From: [Dan Thompson](#)
To: [Deb Estrada](#)
Subject: Re: Public Comment/Notice of Public Hearing – File No. SUB19-002/ (SEP19-005) January 24, 2024/
Date: Tuesday, January 23, 2024 3:42:08 PM

Please consider these my public comments and testimony requesting that the hearing examiner **reject** the city planning department's recommendation for approval for a 14-plat subdivision.

"The Applicant, in response to the public comments received during the SEPA appeal period (Exhibit 12), which ended April 5, 2023, with no appeals filed of the determination of nonsignificance, revised the proposed development (Exhibit 5) by adding an internal shared driveway to serve lots 3, 4, 11, 12, 13, and 14, added a shared driveway for lots 1 and 2, and provided a passive open space easement along West Mercer Way, SE 28th Street, and SE 30th Street that will be planted with native vegetation".

SITE PLAN
2825 W MERCER WAY
PRELIMINARY PLAN
PARCEL #2174502425
CITY OF MERCER ISLAND WASHINGTON

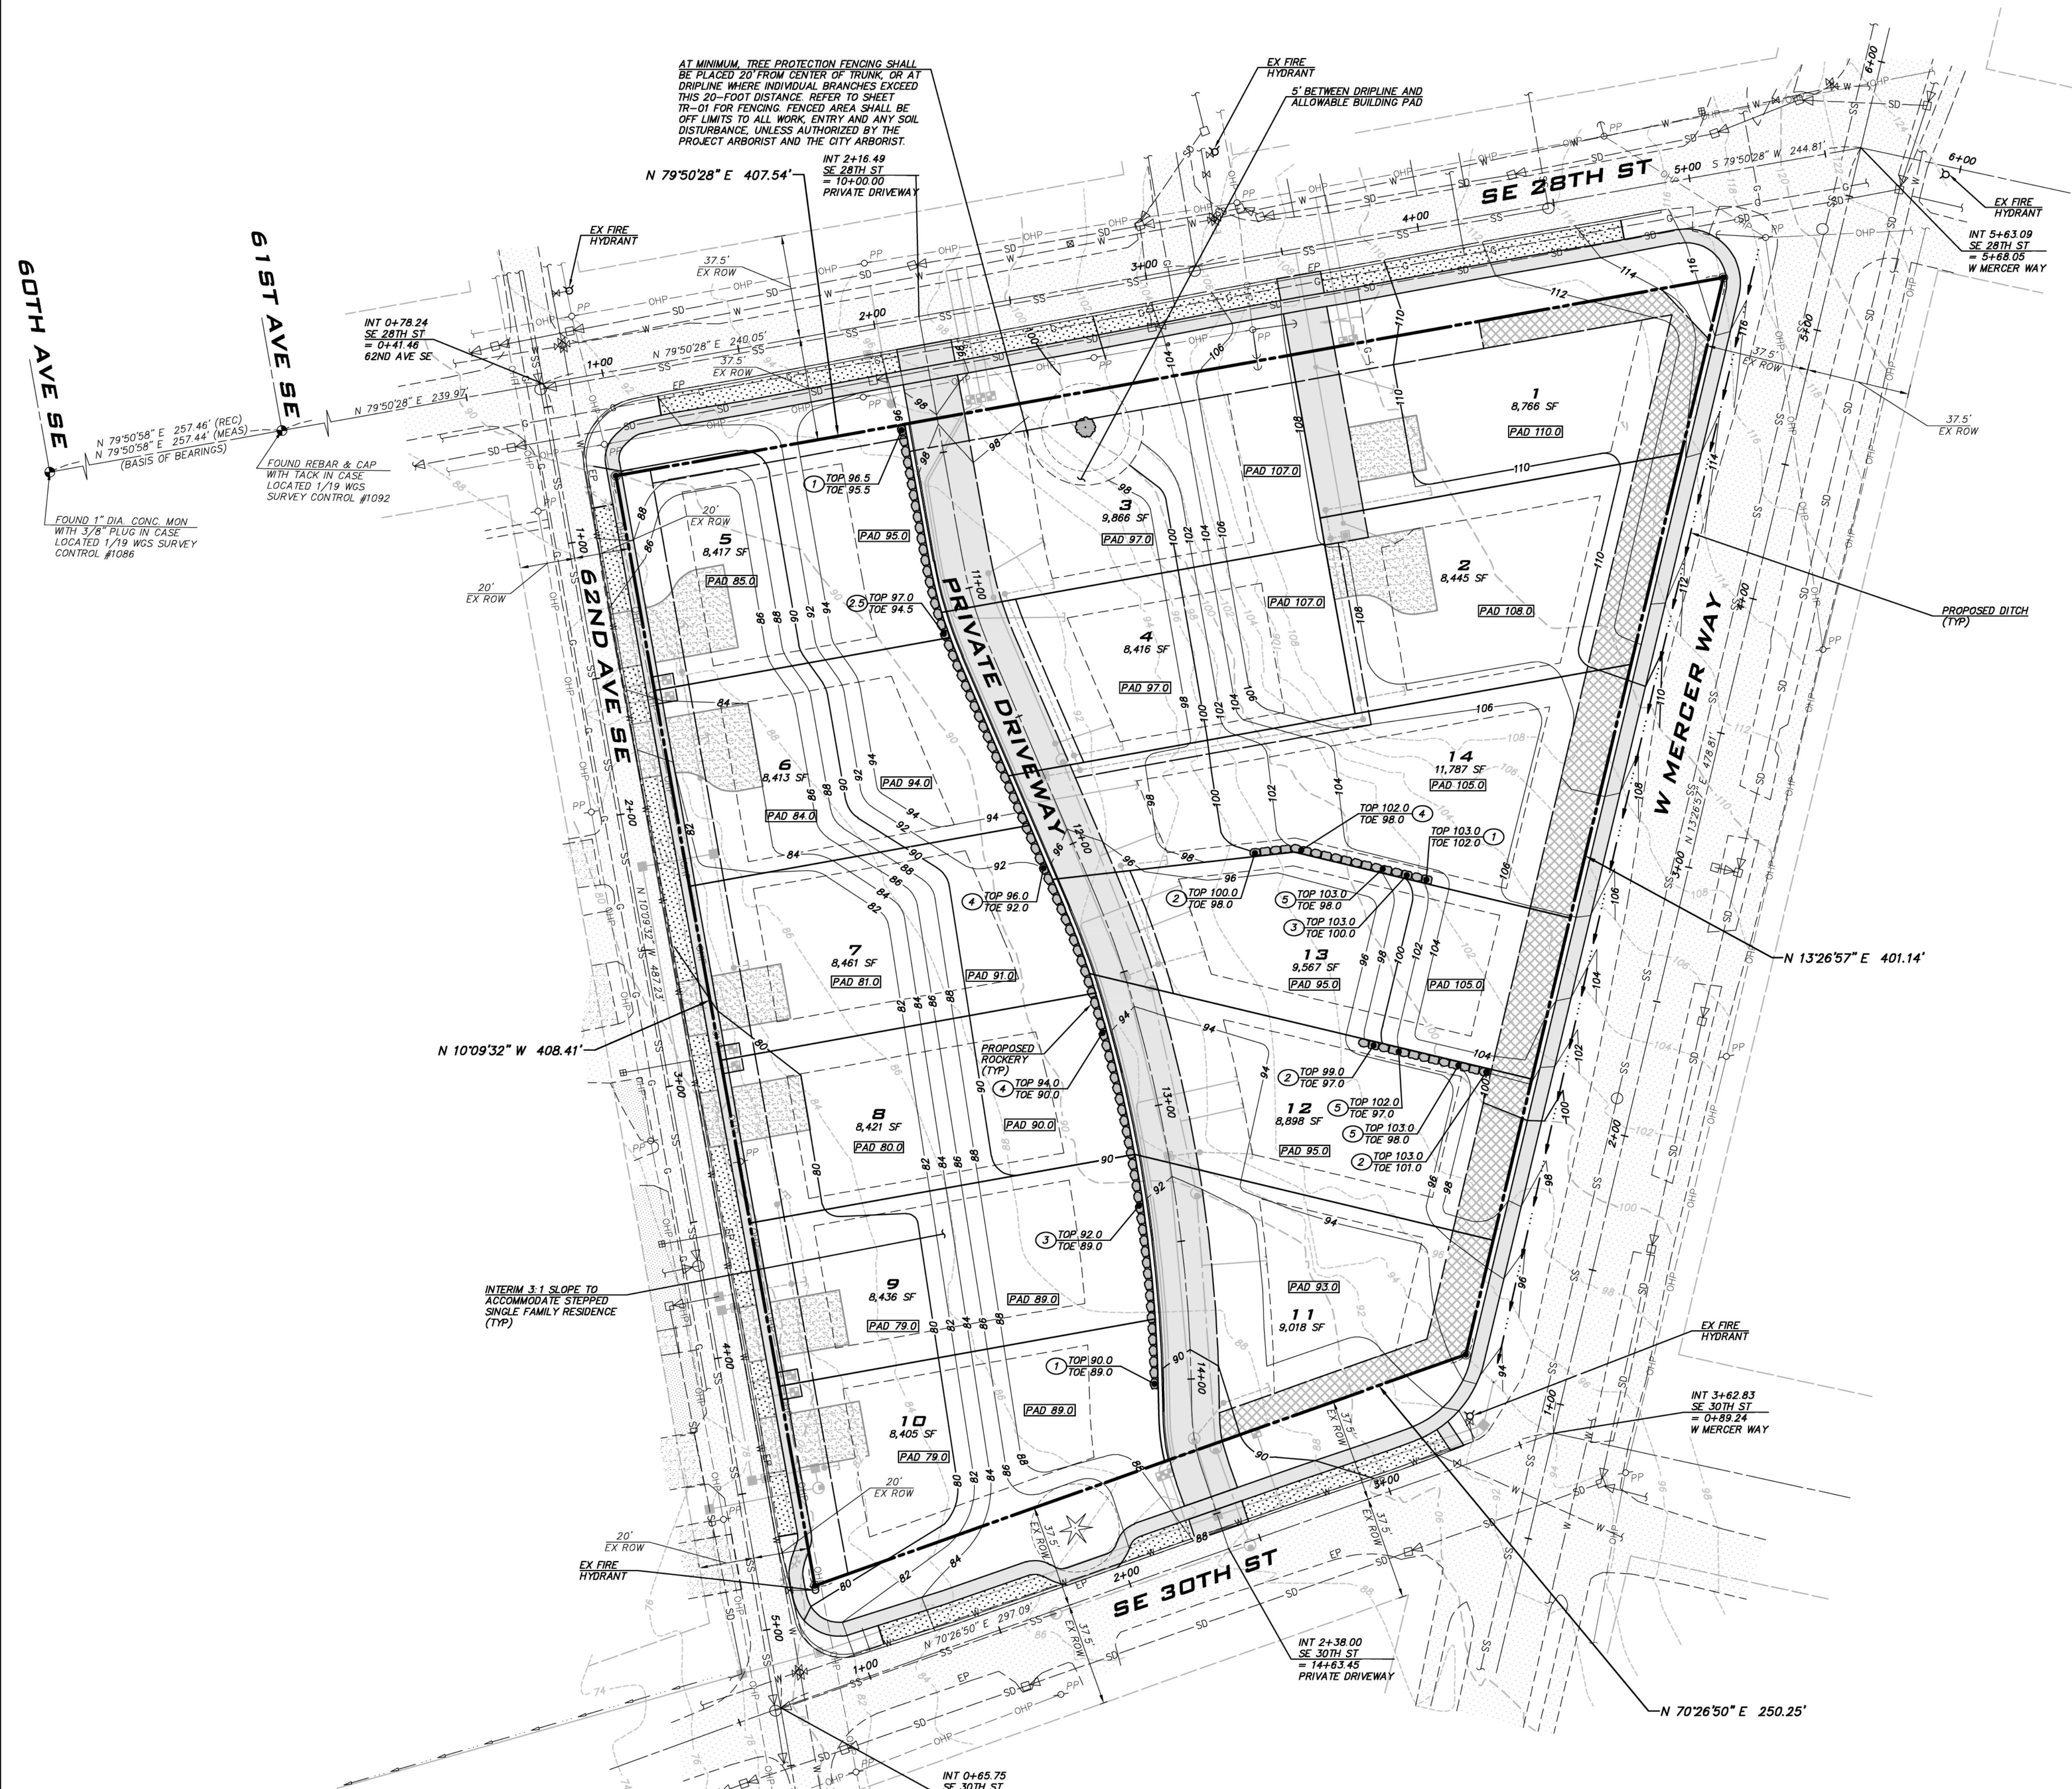
My public comments in 2019 and 2023, and at the public meeting, addressed these deficiencies. As the City's recommendation notes, based on my objections an internal access road **accessing half the plats** was included in the current design, **except to maintain 14 plats any onsite open space was eliminated from the design.**

The applicant's "open space" is based on a tiny existing city park and a tiny triangle of property in the top corner of the property which sits in the setback anyway. Because the planner claims that, *"The MICC does not provide a numerical standard with respect to the level of appropriateness as to the provision of open space"* the planner interprets this to mean the planner has discretion to require essentially zero onsite open space. To call a path to an existing city park "open space" is inconsistent with the requirements of R.C.W 58.17.110 and MICC 19.08.020 and sets a terrible precedent that renders this statute and ordinance meaningless.

As noted above, the applicant's original design was disapproved because it had no internal access road so all 14 lots accessed the surrounding narrow residential streets directly, creating a hazard for pedestrians since there are no sidewalks, and traffic on these residential streets.

The current design includes half an access road, but no open space, simply to maintain 14 lots.

The internal access road should serve all lots. If adequate provision is required for open space there will be space for 13 lots, and an internal access road that serves all lots which will be safer for the neighborhood pedestrians, bicyclists, children, and other traffic. It made no sense to have a 14 lot long plat without any internal access road, and it makes no sense to have a 14 lot long plat with an internal access road that serves only half the lots so the applicant can maintain his goal of 14 lots.

- A. Provide adequate open/park/recreational space onsite consistent with the findings in Coval.
- B. Extend the internal access road to serve all lots.
- C. Reserve until actual building permit applications are filed for each plat the decision whether to allow removal of any tree under the MICC and tree ordinance.
